Rezoning Transportation Analysis

Petition Number: 2023-157

Date	Description
12-27-23	First Review (NK)

REZONING PLAN

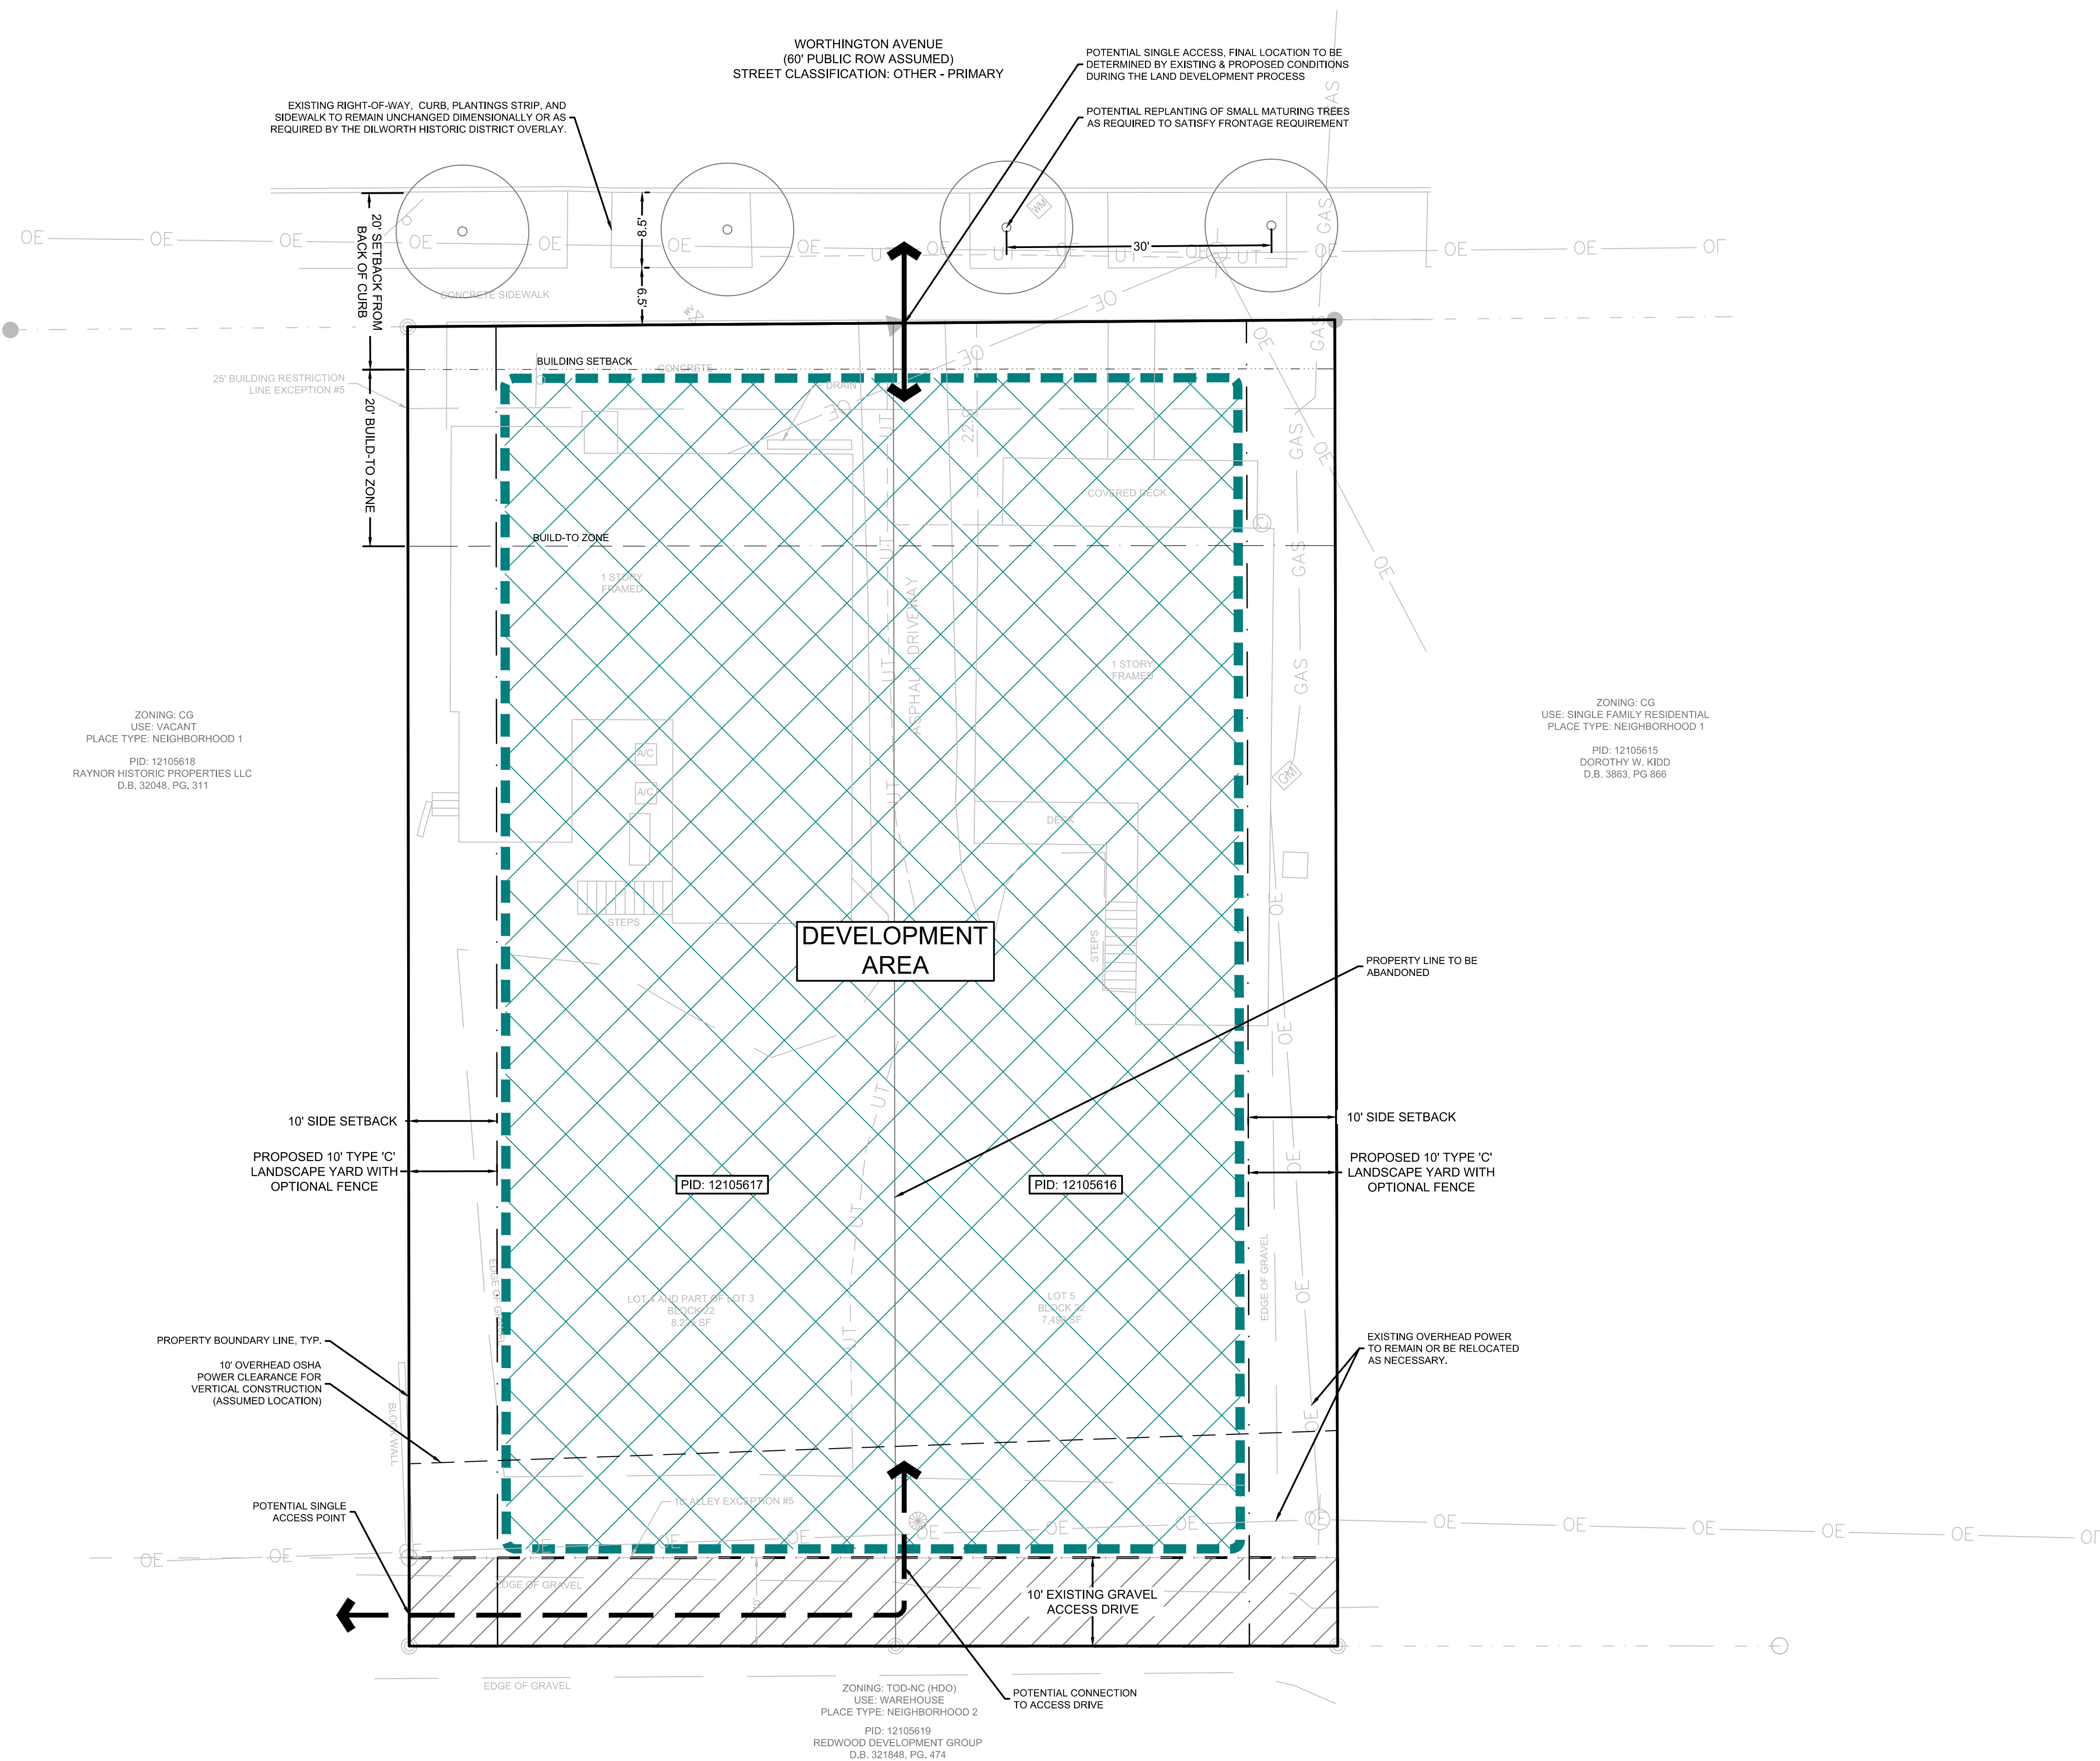
- a. **East Worthington Avenue:** The future location of curb and gutter is in its existing location.

Required Cross Section is CLDSM U-03A1 Local Residential Wide (8' Sidewalk)

Label and dimension the curb and gutter from the centerline for each road on the site plan.

- 3. Revise site plan and conditional note(s) to commit to dedicate 33.5' of right-of-way from the road centerline. The site plan shall label and dimension the right-of-way from the road centerline.

- 5. Revise conditional note under II. Transportation B. The right-of-way, planting strip, and sidewalk along the public frontage of East Worthington Avenue will need to be adjusted according to the comments in this memo.

- 6. Revise site plan and conditional note(s) to commit to installing an 8' planting strip and an 8' sidewalk along Worthington Avenue frontage per UDO articles 32 and 33.

- 7. Revise site plan and conditional note(s) to commit to clearly showing each proposed driveway, site flow and new building locations.
- 8. Revise site plan and conditional note(s) to commit to ensuring the proposed replanting of trees do not impact sight distance at proposed driveway location.
